**From:** Farhad Khatibi  
**Sent:** 30 September 2024 13:29  
**To:** Planning ContactCentre  
**Subject:** RE: Attached letter from Kirklees Council regarding application number 2024/92092 at location 527, Bradford Road, Fixby, Huddersfield, HD2 2LH

typical cross section

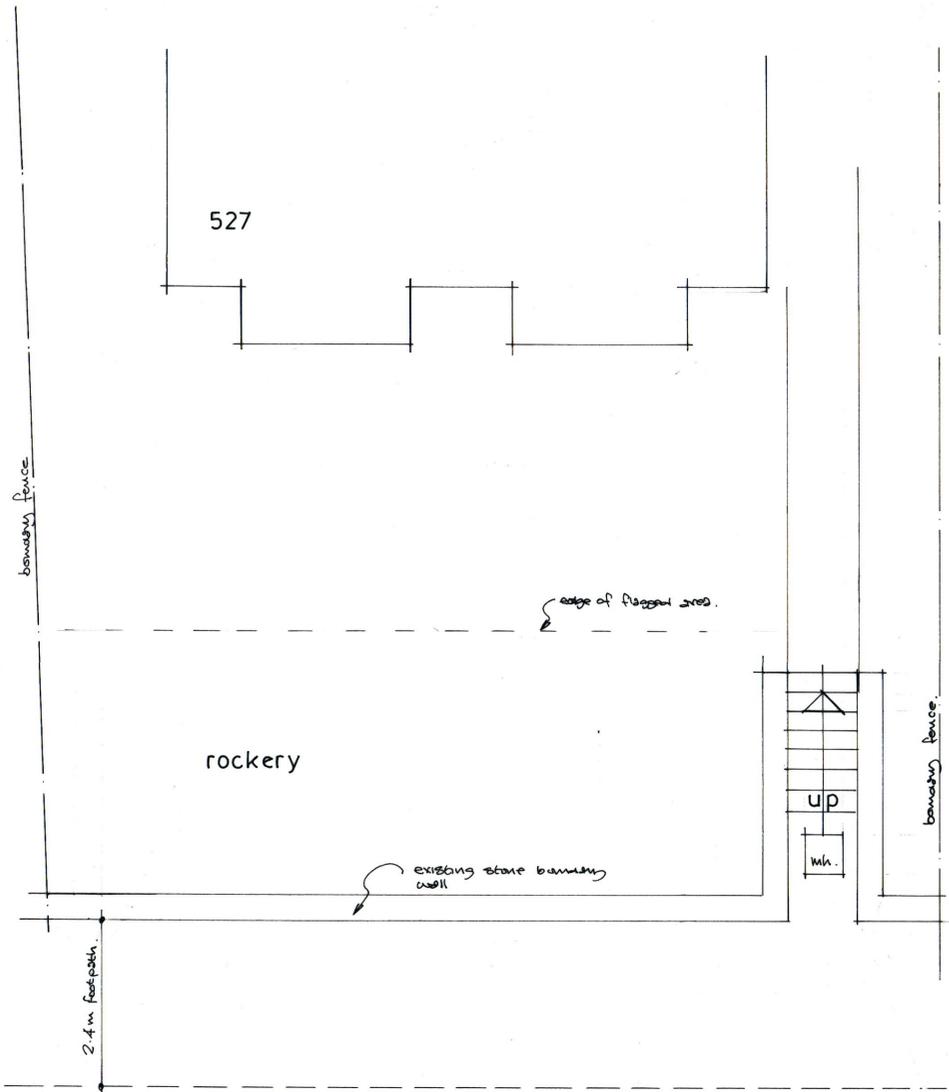
- 1) Before the development commences, the design of proposed private retaining wall at the rear of the new parking space shall be submitted (via submission of an AIP) and approved by the Highway Authority in writing. The approved scheme shall be implemented prior to the commencement of the proposed development and thereafter retained during the life of the development.
- 2) All stones arising from the demolition of the existing highway retaining wall including its half round coping stones to facilitate the construction of the proposed parking space shall be carefully taken down palletted and transferred to the Council's Highways depot at Alder Street, Fartown.
